Application by Highways England for an Order Granting Development Consent for A57 Link Roads

Deadline 8 - response on behalf of High Peak Borough Council

Responses from High Peak Borough Council are provided in red to outstanding matters discussed in the hearing session held during the week commencing 4th April 2022.

- LEGEND**
- MODELLED QUALIFYING FEATURES AND PUBLIC ACCESS
  - DEFRA PCM LINKS COINCIDING WITH ROADS MEETING THE DMRB LA105 TRAFFIC SCREENING CRITERIA
  - ROADS MEETING DMRB LA105 TRAFFIC SCREENING CRITERIA

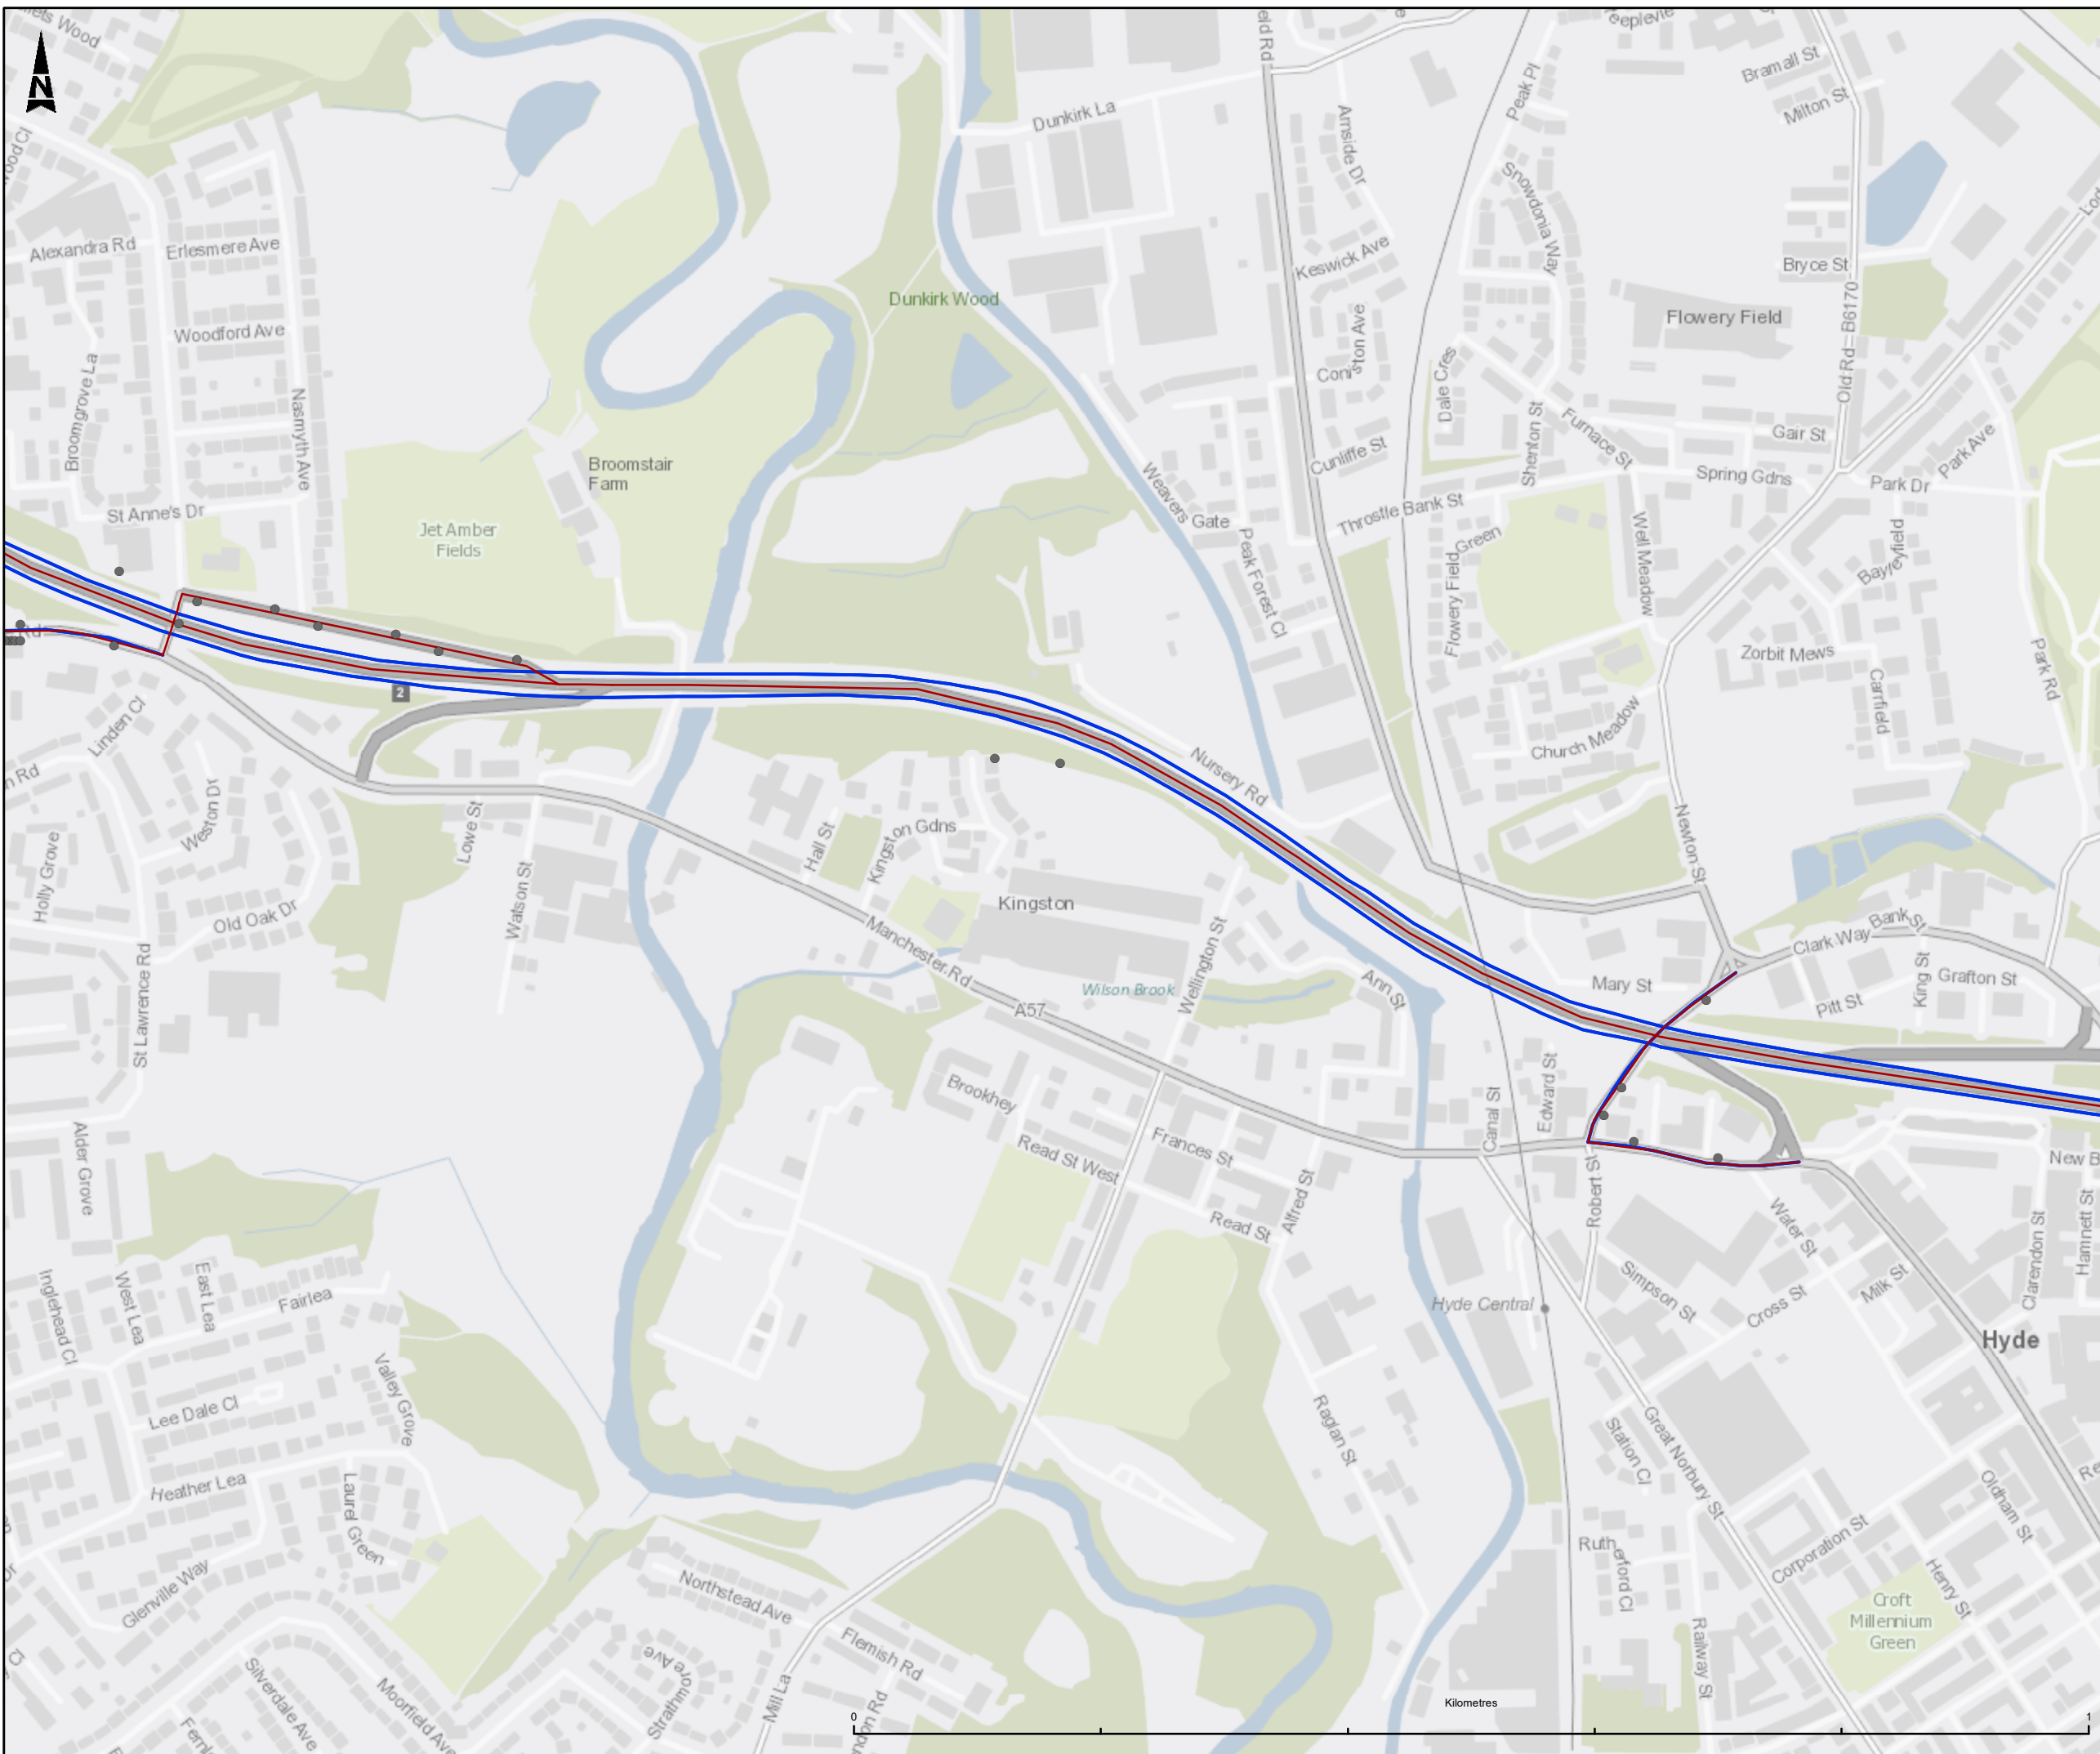
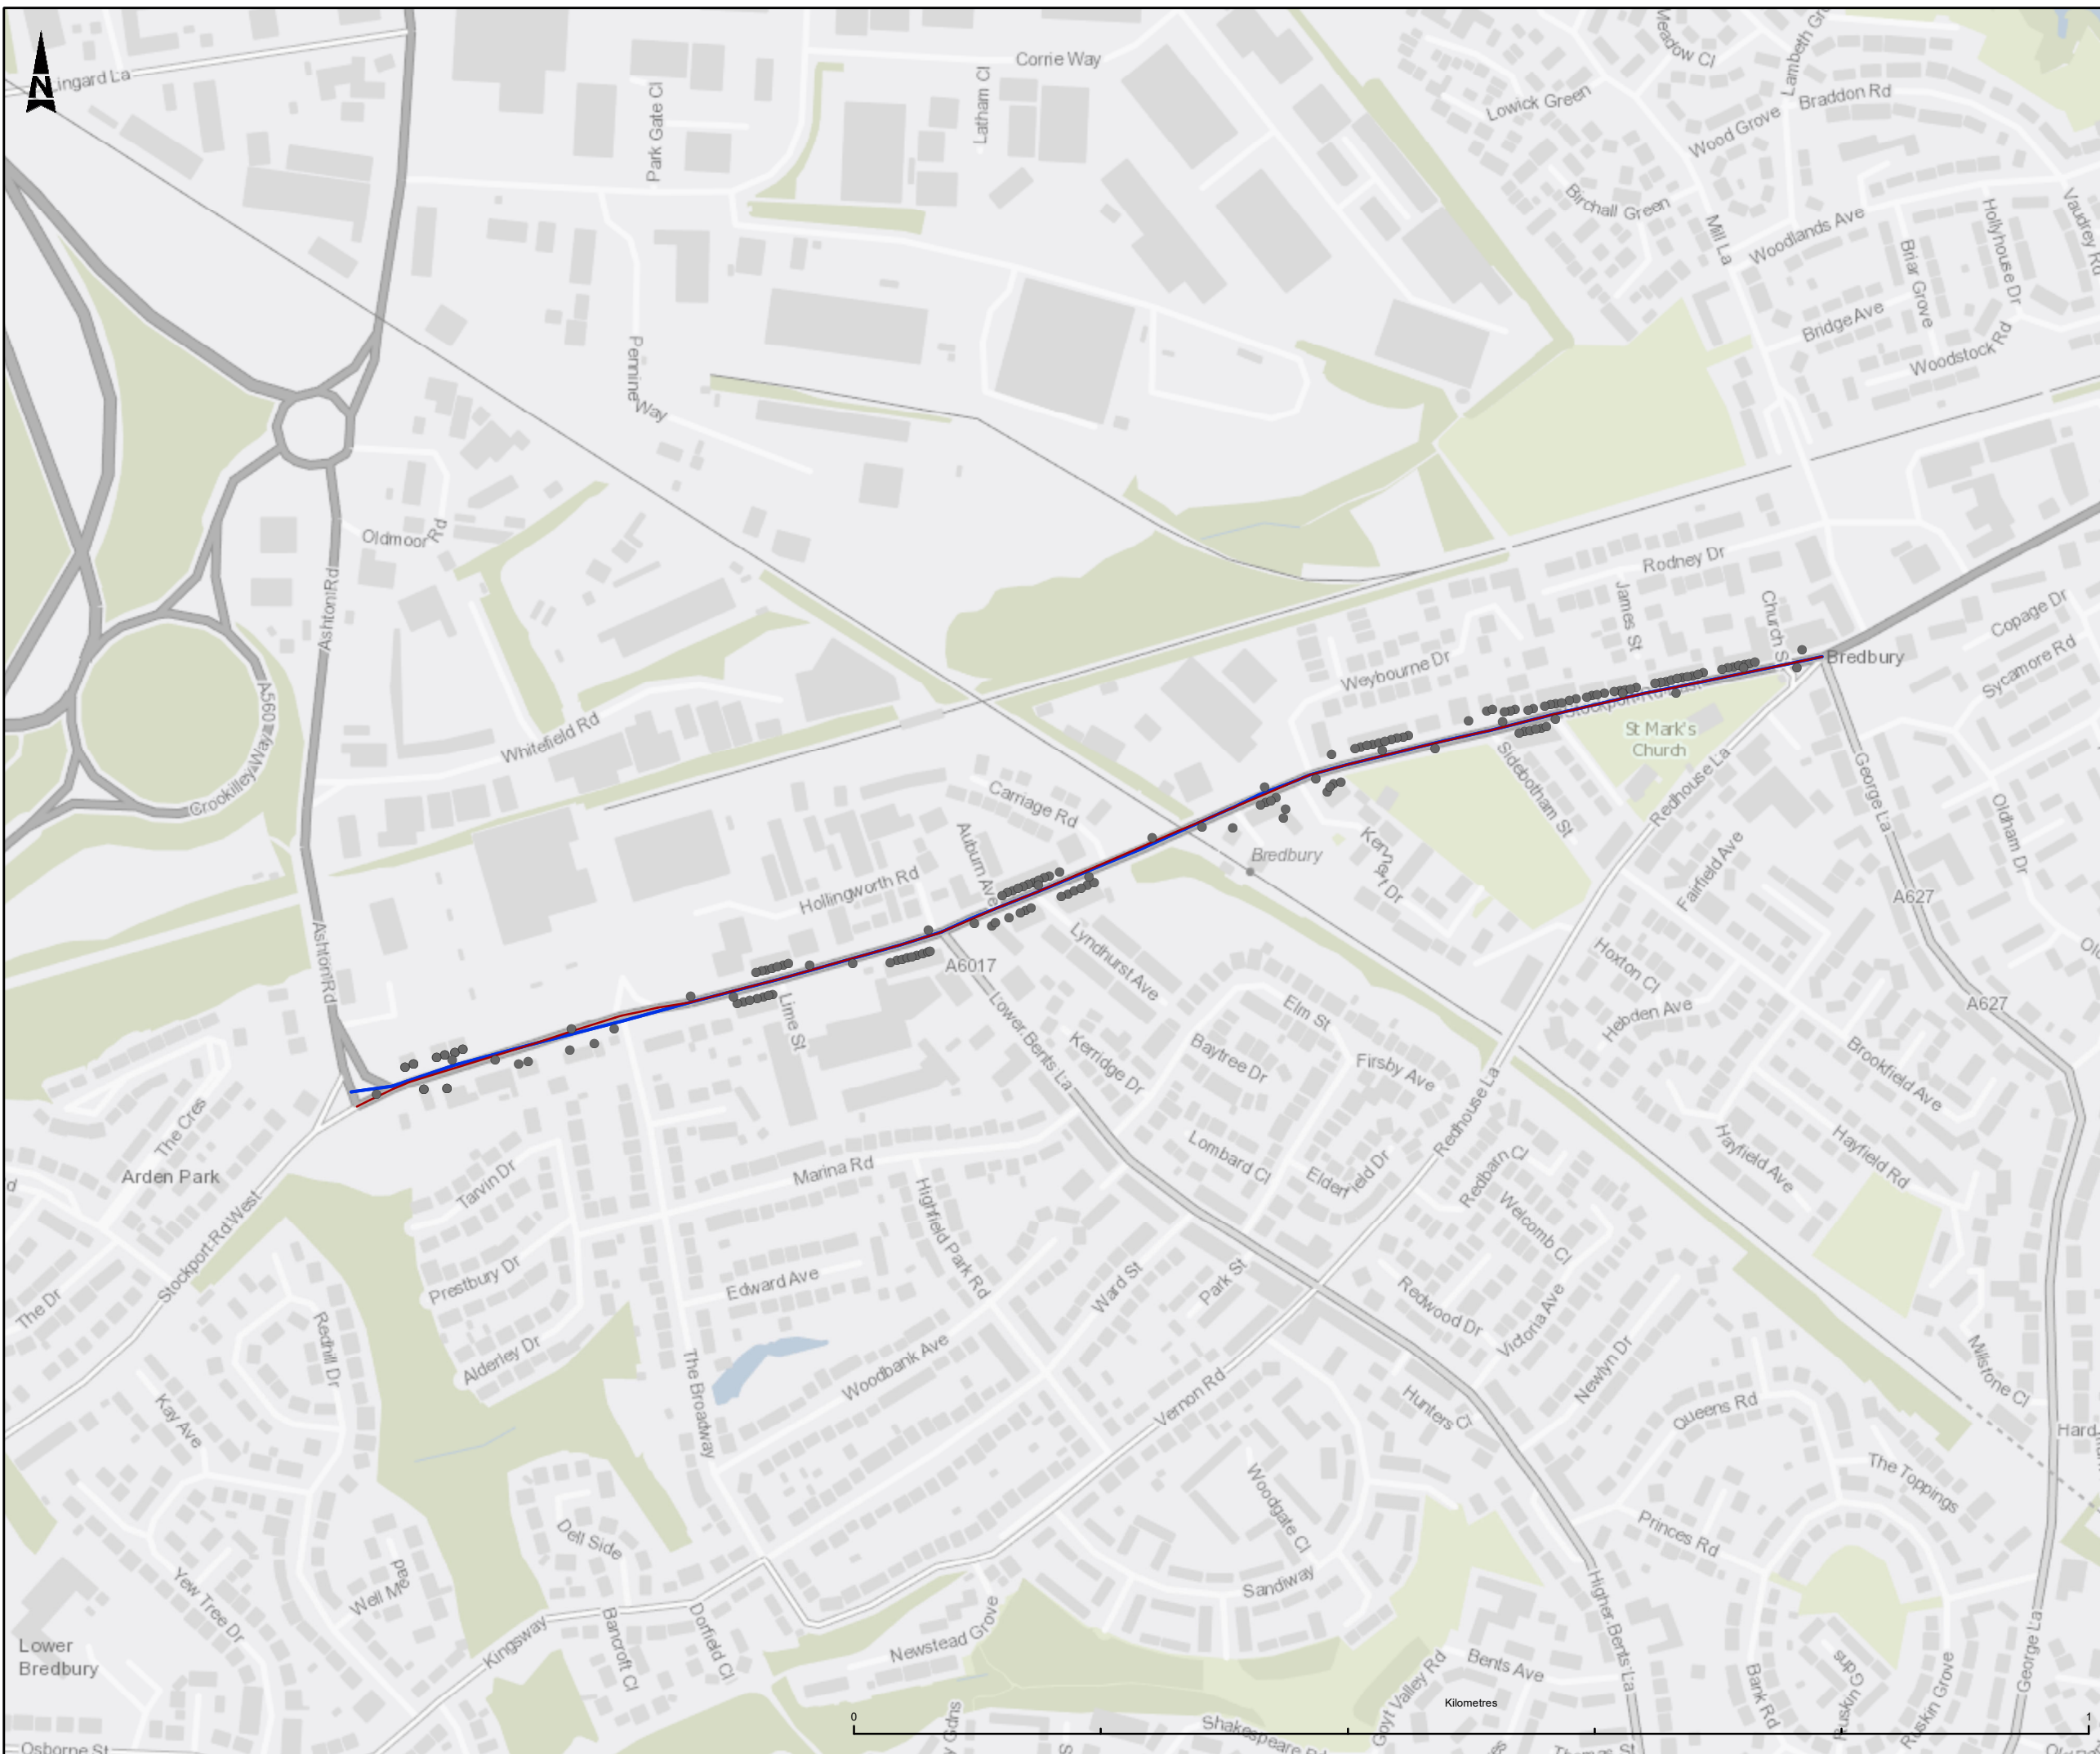
<u>Figure 5.4 Air Quality Compliance Risk Assessment – receptor labels</u>			
<p><u>Item 8.38</u> HPBC [REP4-011] asked for the A57 Brookfield qualifying features used in the NO2 compliance assessment to be</p>	<p>Given the number of qualifying features and public access receptors included in the compliance assessment it was not possible to practically label the qualifying features in ES Figure 5.4 (APP-080) however,</p>	<p>Agreed Deadline 8 update (HPBC) It is noted that this response was supplied at deadline 7 by NH. Clarification of receptors</p>	<p>Closed</p>

HPBC Item	National Highways Position	HPBC Position	Status
	<p>traffic scoping criteria requiring further assessment.</p> <p>The temporary traffic management measures will generally be short term, with the arrangements, timing and phasing being designed to minimise traffic congestion and delay far as reasonably practicable. Inevitably, however, some of the temporary traffic management arrangements are likely to cause some additional short term traffic congestion and delay within the immediate vicinity of the Scheme, but this is not anticipated to be sufficient to result in any material change in traffic flows or congestion on roads within HPBC.</p> <p>The approach to the assessment of the impact of construction traffic management has been further discussed and agreed with HPBC (virtual meeting held 4th March 2022).</p>		
<u>Human health receptors A57 Brookfield</u>			
<p><u>ISH 3 Item 5 Air Quality Question j</u></p> <p>Within the response to question j, HPBC raised a concern regarding the</p>	<p>Following further discussion and clarification with HPBC (virtual meeting held 8th April 2022) it has been agreed that a sensitivity test will be undertaken to identify the air quality impact at relevant qualifying</p>	<p>Deadline 8 update (HPBC) Further to Item 8.38; Identification of the receptors (figure 5.4) used in the compliance risk assessment</p>	<p>Open</p>

HPBC Item	National Highways Position	HPBC Position	Status
<p>magnitude of change reported in the compliance risk assessment at qualifying feature receptors adjacent to the A57 Brookfield.</p>	<p>feature receptors located adjacent to the A57 Brookfield under the DMRB LA 105 human health assessment methodology.</p>	<p>(using LAQM “conservative” forecast”) indicated that “large” change at some of the receptors along Brookfield. However, it also highlighted that some of these were human health receptors that had not been included as receptors in the (less conservative) primary human health AQ assessment (DMRB LA 105). Therefore, HPBC have requested that these receptors are also assessed in accordance with the DMRB LA 105</p>

HPBC Item	National Highways Position	HPBC Position	Status
labelled on ES Figure 5.4 [APP-080].	an extract of ES Figure 5.4 zoomed in on the A57 Brookfield area with receptor ID labels for qualifying features and public access receptors adjacent to the A57 Brookfield is provided below this table.	did highlight that there were some relevant receptors in the Brookfield area that had not been included in general AQ assessment but had been included in the compliance assessment (see final row)	
<u>Adjustment of Background Concentrations Data used in Air Quality Assessment</u>			
<p><u>Item 8.39</u></p> <p>HPBC raised concerns about the lack of adjustment to the background concentrations used in the air quality assessment. HPBC [REP4-011] suggest they are concerned about over representation of beneficial effects.</p>	<p>The HPBC query relates to the verification and adjustment of the Department for Environment, Food and Rural Affairs (Defra) mapped background concentrations. National Highways provided a response to question 8.39 in REP3-018. As stated in REP3-018, where the Defra background maps underpredict background monitoring data this could lead to a need to apply a higher adjustment factor in the air quality model verification. The higher the adjustment factor applied, the more conservative the results of the assessment given that the adjustment is applied to both the modelled total concentration with and without the Scheme, which has the effect of increasing the change in concentration. Where concentrations</p>	Agreed	Closed
